**KIRKLEES METROPOLITAN COUNCIL
INVESTMENT & REGENERATION SERVICE**

**DELEGATED DECISION TO DETERMINE APPLICATIONS FOR
CONSENT, AGREEMENT OR APPROVAL REQUIRED BY CONDITION**

Reference No:	2023/44/92359/W
Site Address:	Land at, Station Road, Meltham, Holmfirth, HD9 4NL
Description:	Discharge condition 7 (improvement works to Station Road), 10 (Validation Report) on previous permission 2022/93376 for erection of 7 detached dwellings including associated car parking and turning head
Recommending Officer:	John Holmes

DECISION – Details for conditions 7 and 10 approved

Project	Station Road Meltham		
Client	Brierstone Ltd.		
Drawing	Hard Paving Specifications		
Number	1309-902	Rev	A
Scale	1:200@A1	Drawn	SJG
		Checked	
		Date	Jul 2022

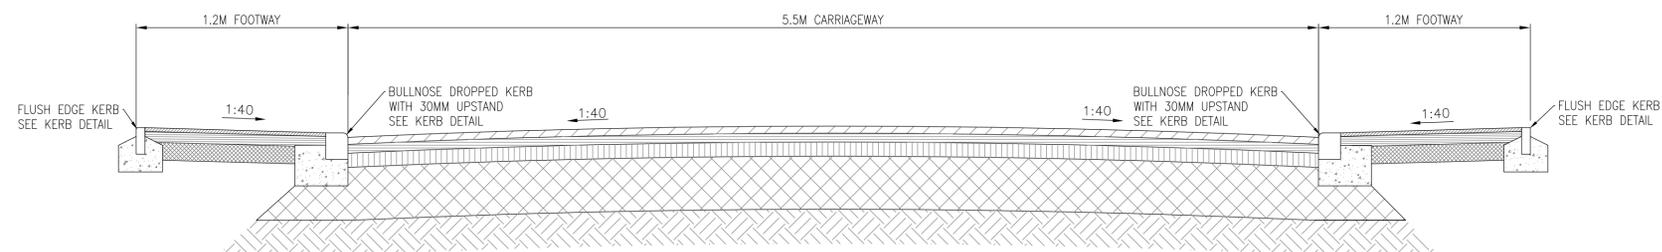
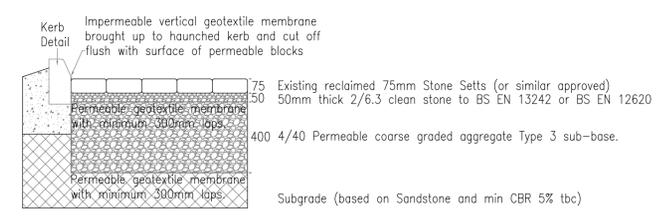
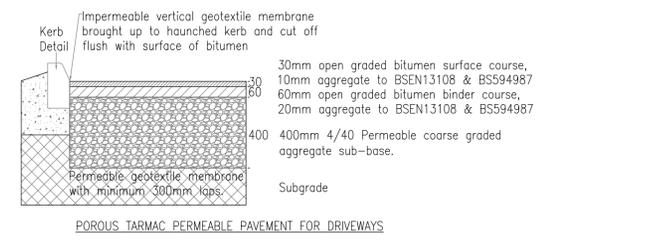
The Council's Highways Structures Team confirm they have no comment to make. The Highways DM Team have also been consulted regarding this application, and set out in their response that the submitted plan details the construction details for the turning head, access road (Station Road) and the driveways. They confirm in their response that the submitted details demonstrate that the construction will be carried out to adoptable standards (although it is noted that the highway is unadopted and unlikely to be offered for adoption). They conclude that they consider the submitted scheme to be suitable for the discharge of condition 7.

The condition requires details of the surfacing/re-surfacing, drainage, provision of the footway, drawing 1309-902RevA sets this out with permeable paving to driveways / the footpath. Whilst only one footpath is shown on the site plan (and two shown on the section) upon drawing 1309-902RevA, it is considered that the provision of the footpath to the section adjacent to the dwellings is sufficient. Furthermore, taking account of the response of the

Highways Team and the submitted detail and details from LLFA during the course of the application, it is considered the drainage arrangements for the highway are suitable.

The submitted scheme details using the existing and reclaimed / new stone setts.

The submitted scheme is considered to be acceptable to the LPA in terms of the requirements of condition no.7, and having regard to the details submitted and response of the Highways Team, the submitted scheme includes a reasonable timeframe for the implementation and completion of the works and it is considered that the proposed scheme detailed in the submitted plan is acceptable.

It is therefore recommended that condition no.7 is satisfied and discharged, there is a requirement that the development is undertaken in accordance with the timeframe approved by this condition with the works to be completed by February 28th, 2025, and that upon completion of the works the approved scheme shall be retained thereafter.

Drawing Title:
Photographic Record Sheet 1
Plots 1 & 2
Gas Membrane Validation

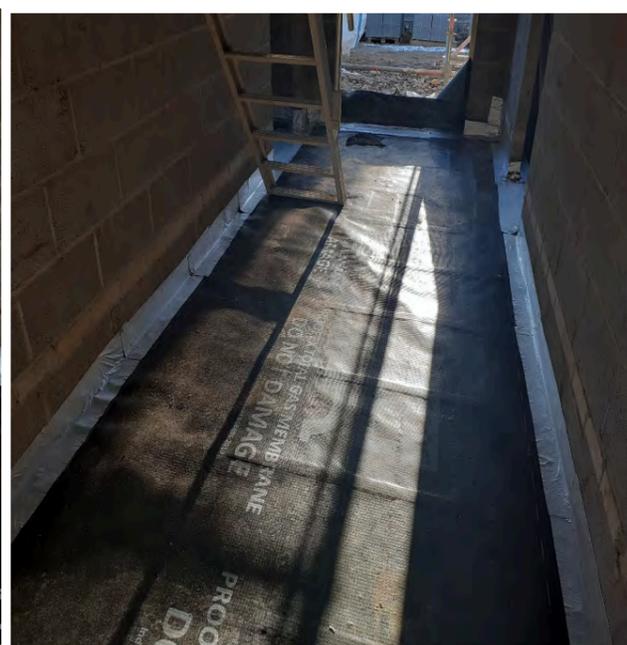
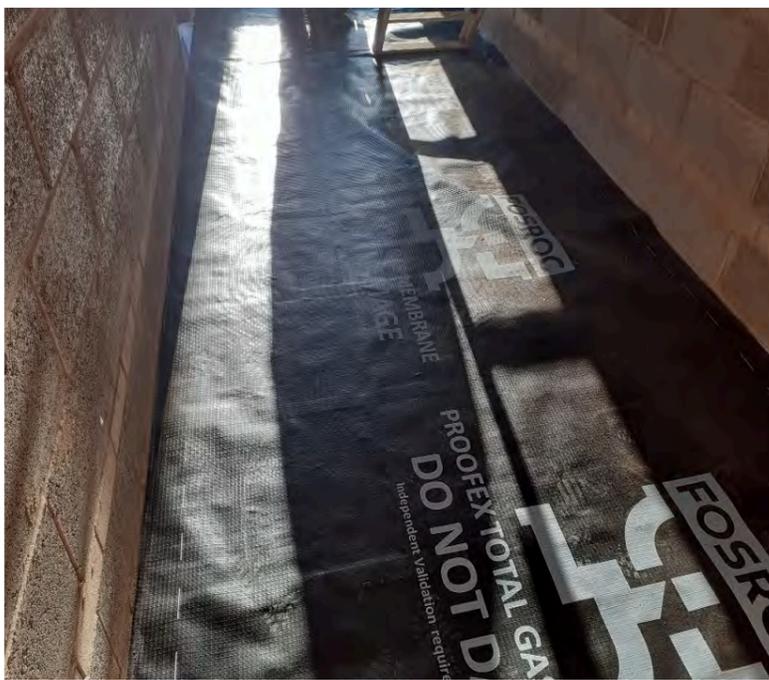
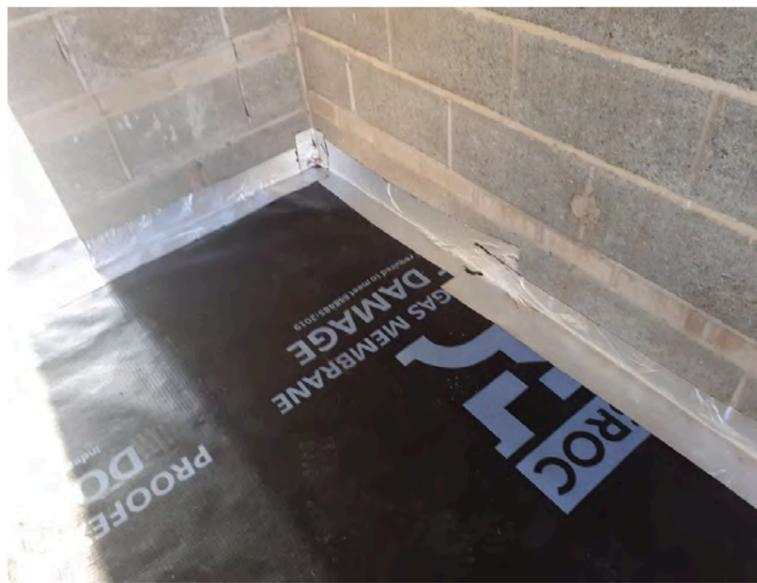
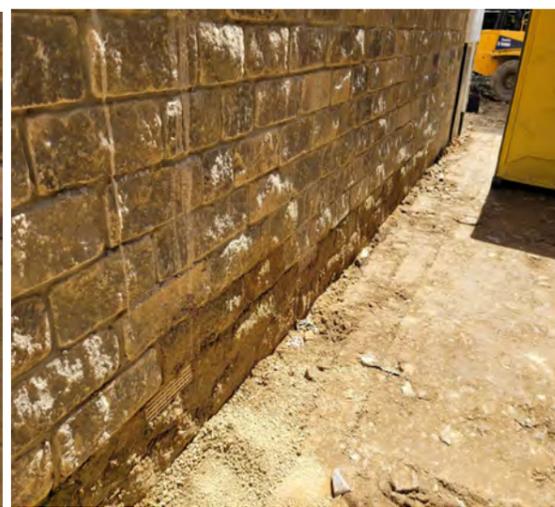
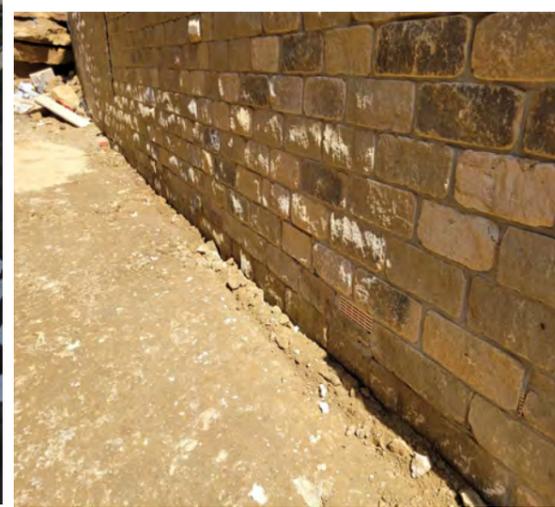
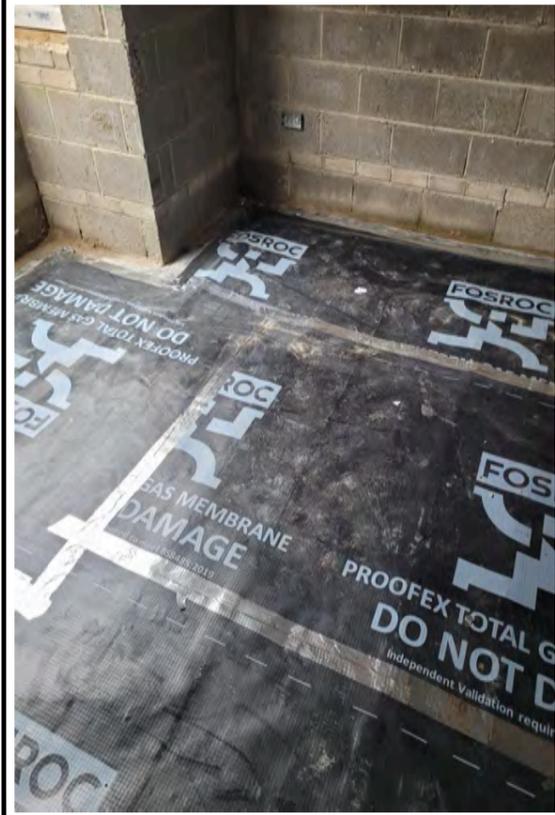
The Council's Environmental Health Team have been consulted, and initially advised the submission sets out that the installation of conventional strip foundations with a suspended block and beam floor with a sub-floor void, a passive ventilated sub-floor void and the installation of a hazardous ground gas barrier membrane was undertaken. They go on to note that the condition of the gas barrier was confirmed as being 'generally good' and any minor tears or punctures detected were suitably repaired using a gas-resistant self-adhesive membrane. In addition, all joints are described as sealed using double-sided jointing tape with a secondary seal of the overlap with gas-resistant tape.

They noted that the submitted details set out that all overlaps were equal to or greater than 100mm in accordance with manufacturers' guidelines and that service entries and service duct seals in the floor slab were found to be sealed to the gas barrier using preformed top hats and gas resistant self-adhesive membrane. They finally note that the report also explains that service ducts will be sealed later, and photographic evidence of the installation has been provided.

The Environmental Health Team confirmed that they were generally satisfied with the information presented. However, they required additional confirmation that the service ducts have been sealed as these can act as pathways for ground gases.

Further photographs were provided, with an email dated 4th September 2023 however the Environmental Health Team confirmed in an email dated 19th October that they had reviewed the photographs but there was no supporting commentary and there was questionable taping etc. They advised that they would expect a supporting commentary and any service entries seals to be verified as the rest of the gas protection elements to ensure the system provides the necessary protection to the end-user.

The document submitted with the 31st January email has been reviewed by the Council's Environmental Health Team who advise that further to their comments (dated 4th September 2023) they have received additional confirmation that the service ducts have now been sealed, supporting document by HNA Architects. They subsequently advise they have no objection to the discharge of condition no.10.

Having regard to the submitted detail and response of the Environmental Health Team, it is considered that the submitted scheme satisfies the requirements, and sets out an acceptable scheme, in relation to condition no.10. Therefore it is recommended this condition is discharged.
